**KIRKLEES METROPOLITAN COUNCIL
INVESTMENT & REGENERATION SERVICE**

**DELEGATED DECISION FOR APPLICATION FOR CERTIFICATE OF
LAWFUL DEVELOPMENT**

Reference no.: 2021/CL/94397/E

Site: 34a, Huddersfield Road, Skelmanthorpe,
Huddersfield, HD8 9AS

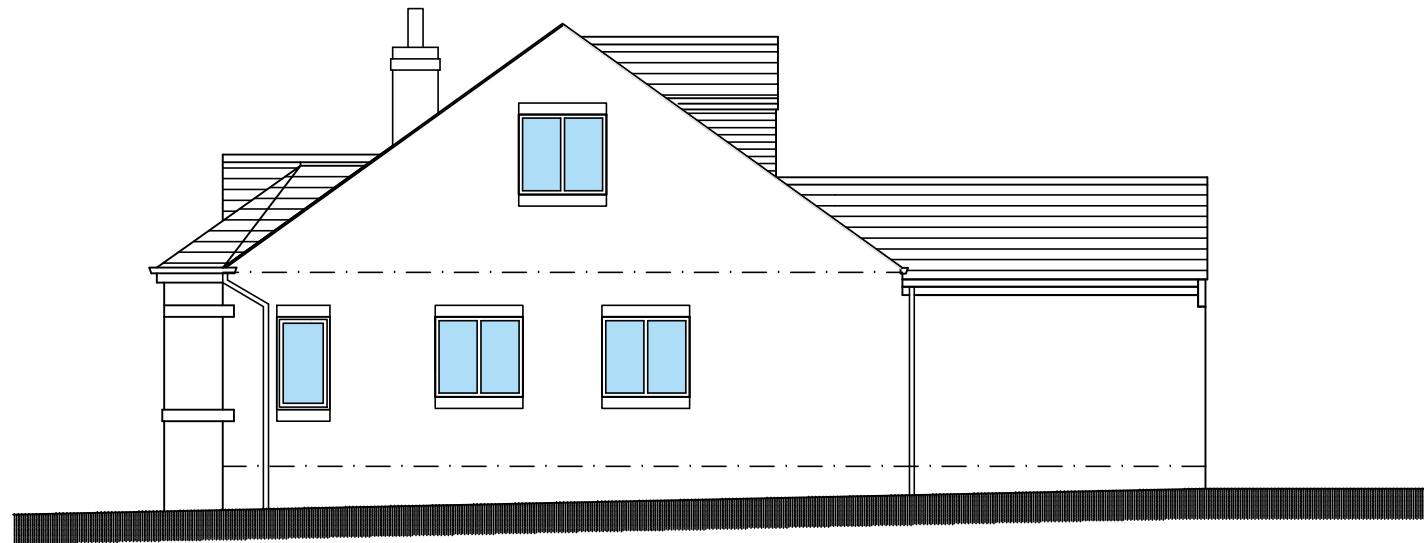
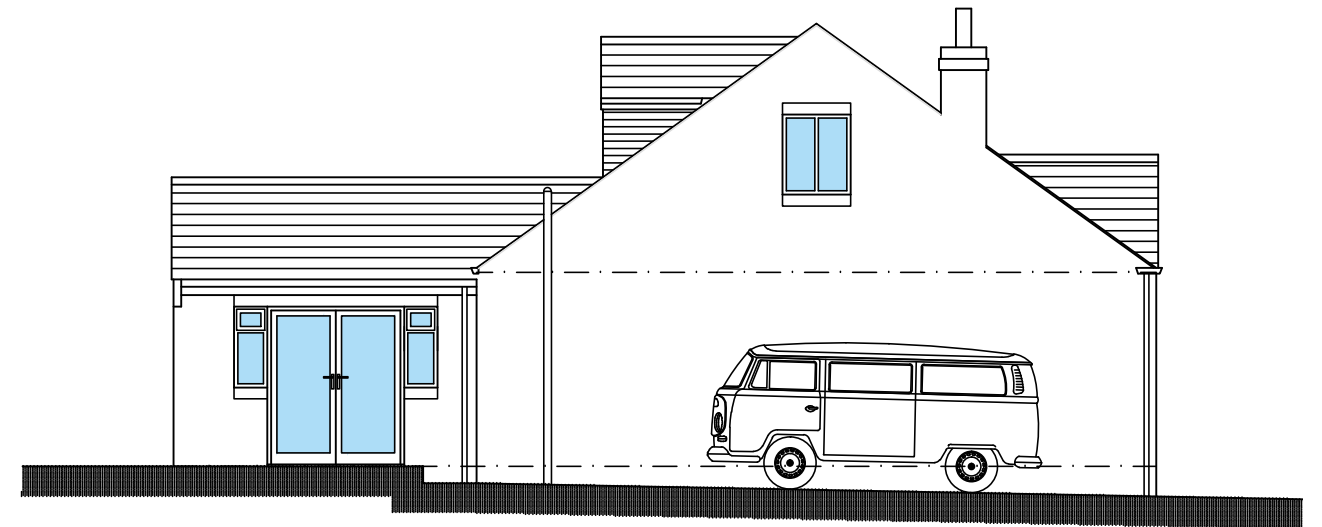
Permission is sought for a Certificate of Lawfulness for the erection of a rear dormer. The proposed dormer would measure approximately 4.2m deep x 6.7m wide x 2.4m maximum height. The dormer would have a mono-pitch roof.

Comment: The height of the highest part of the existing roof would not be exceeded by the proposed dormer.

Comment: The proposed rear dormer would not extend beyond the plane of any existing roof slope forming the principal elevation of the dwellinghouse and which fronts a highway.

Comment: *The cubic content of the resulting roof space would not exceed the cubic content of the original roof space by more than 50 cubic metres. The original rear dormer would be removed (3.7 cubic metres). The proposed rear dormer is 40.6 cubic metres and the existing roof space on the single-storey rear extension is 13 cubic metres. The resulting roof space is therefore 49.9 cubic metres above the original roof space.*

Amended plans were requested and received from the agent showing a reduction in the size of the proposed dormer to comply with sub-paragraph (d).

PROPOSED HOUSE EXTENSION
34a HUDDERSFIELD ROAD, SKELMANTHORPE, HD8 9AS
DWG No. 496-A02 revB
SCALE 1:100@A3 JULY 2021

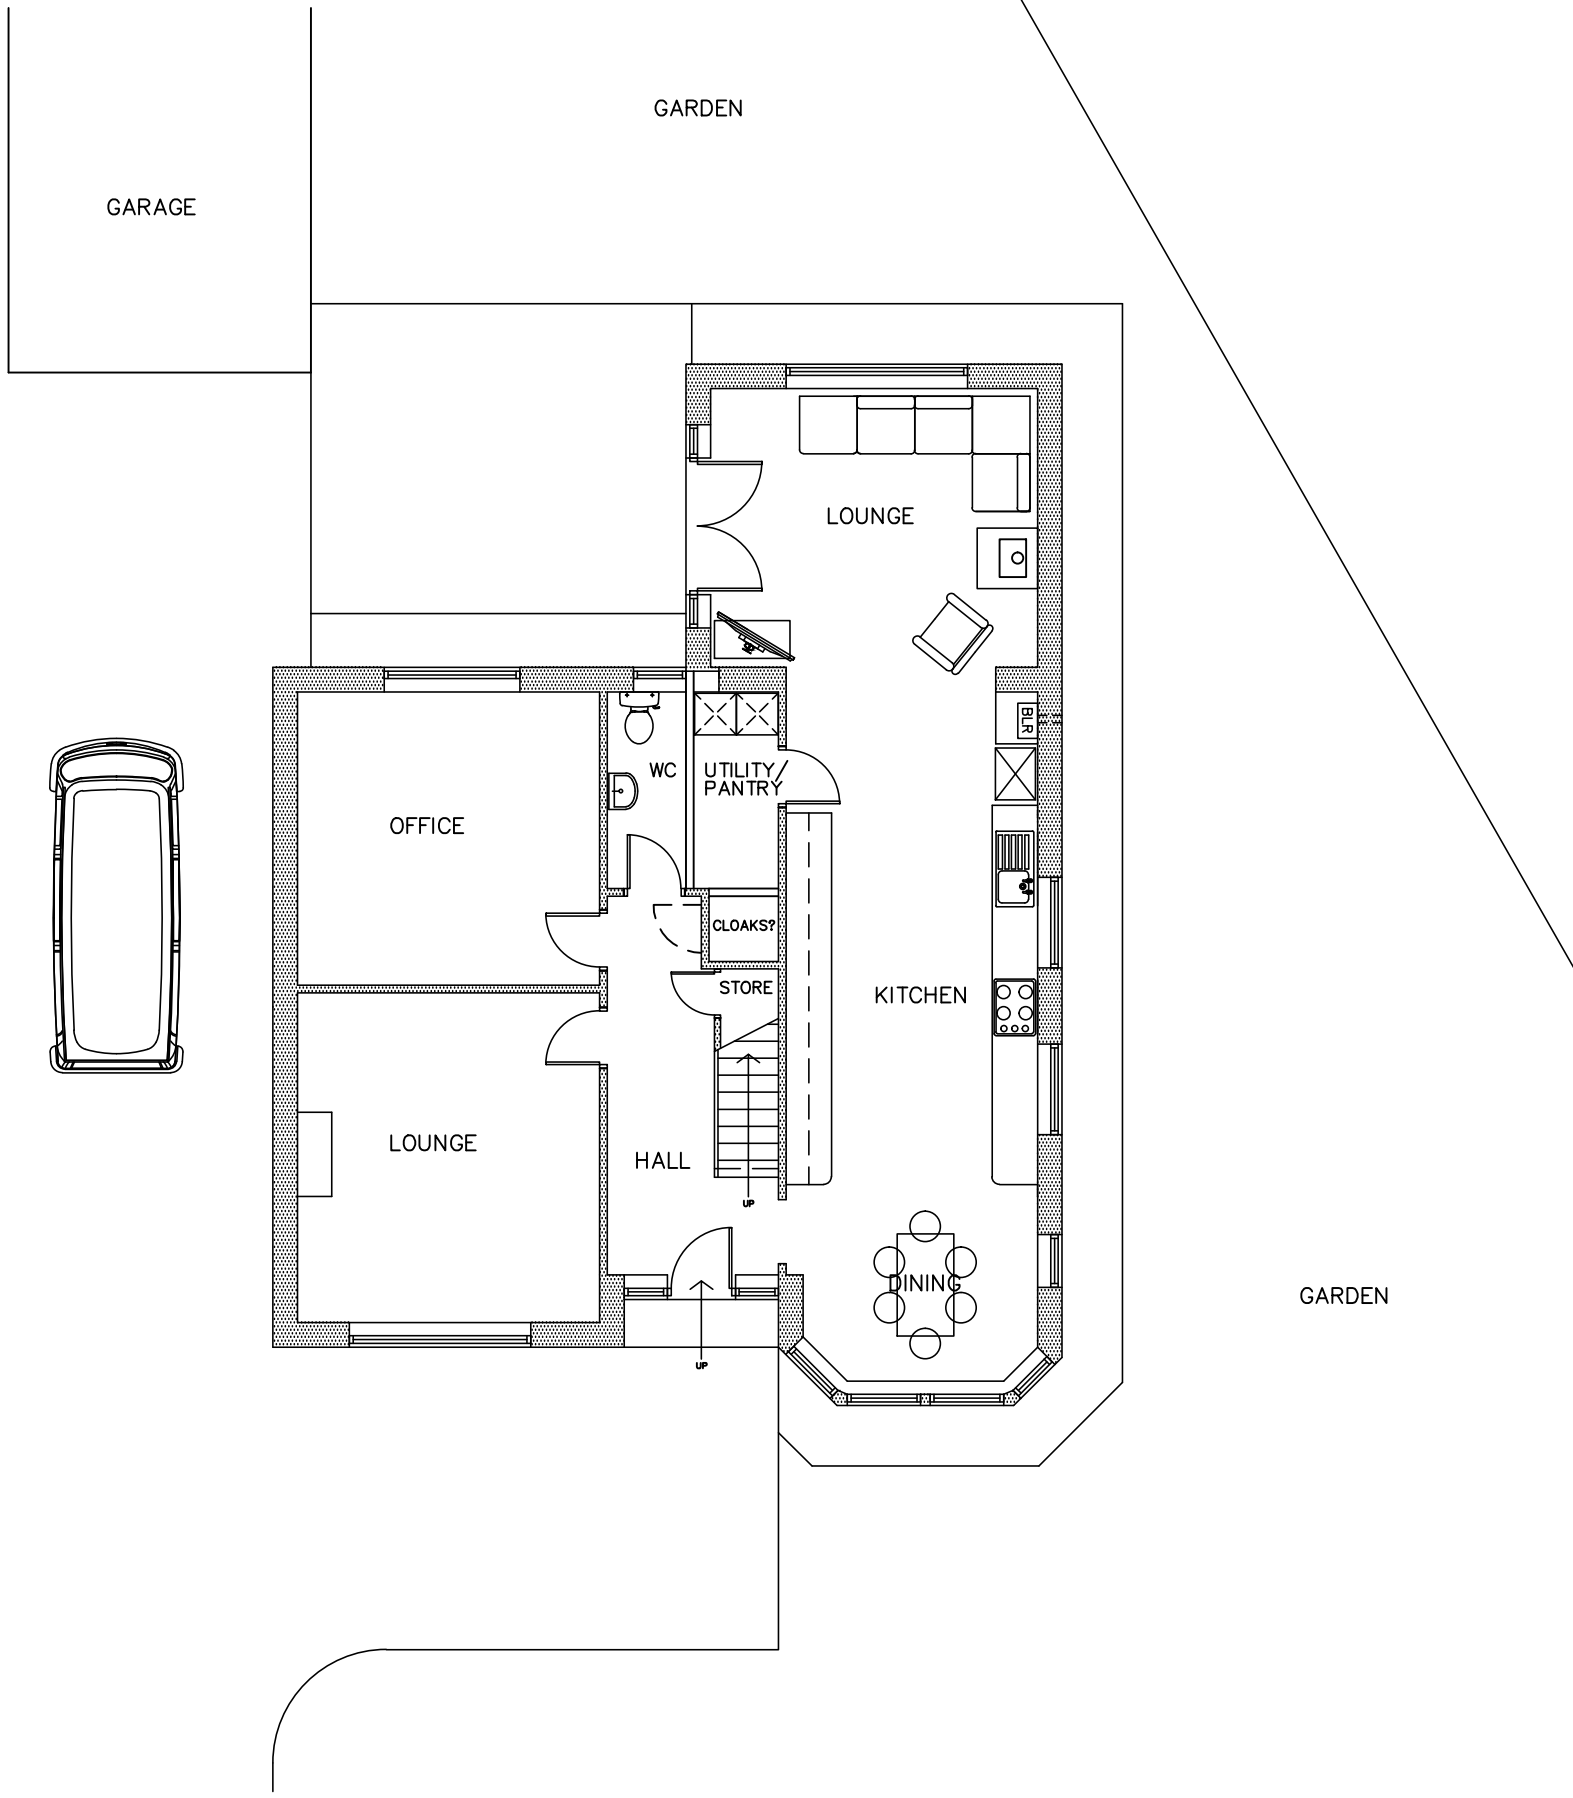
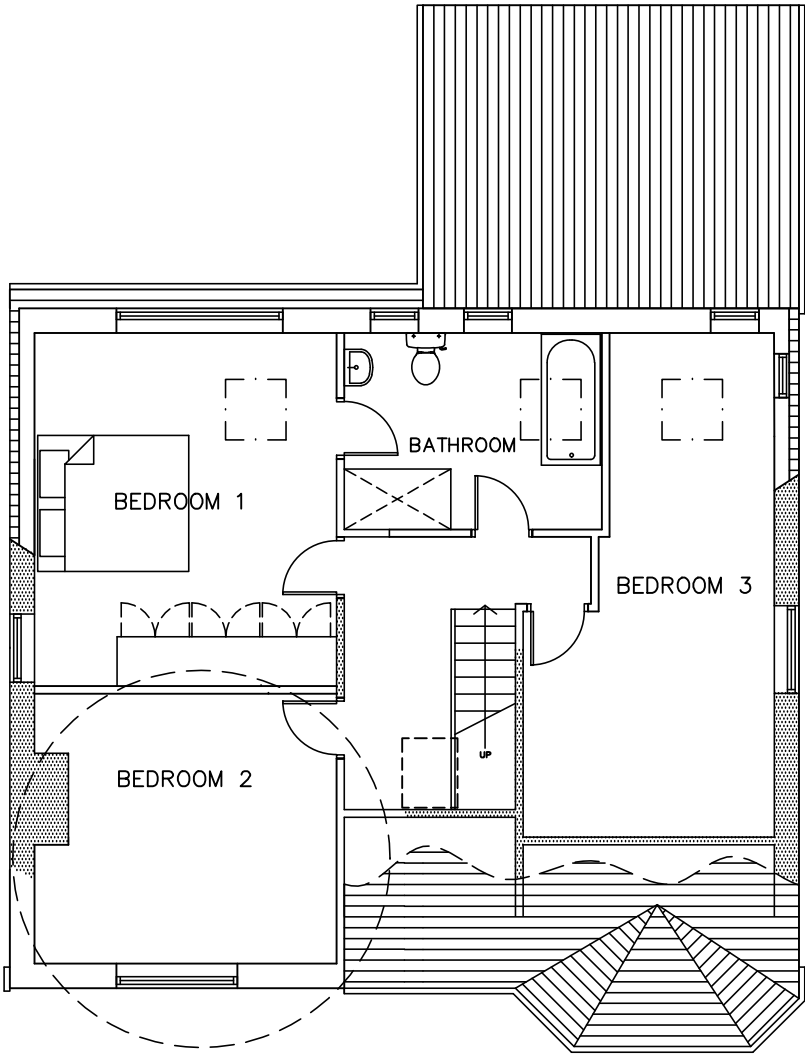
It is noted that the submitted plans also show a first-floor extension to the front; this is the subject of planning application 2021/93308. The certificate of lawfulness is to cover the proposed rear dormer only.
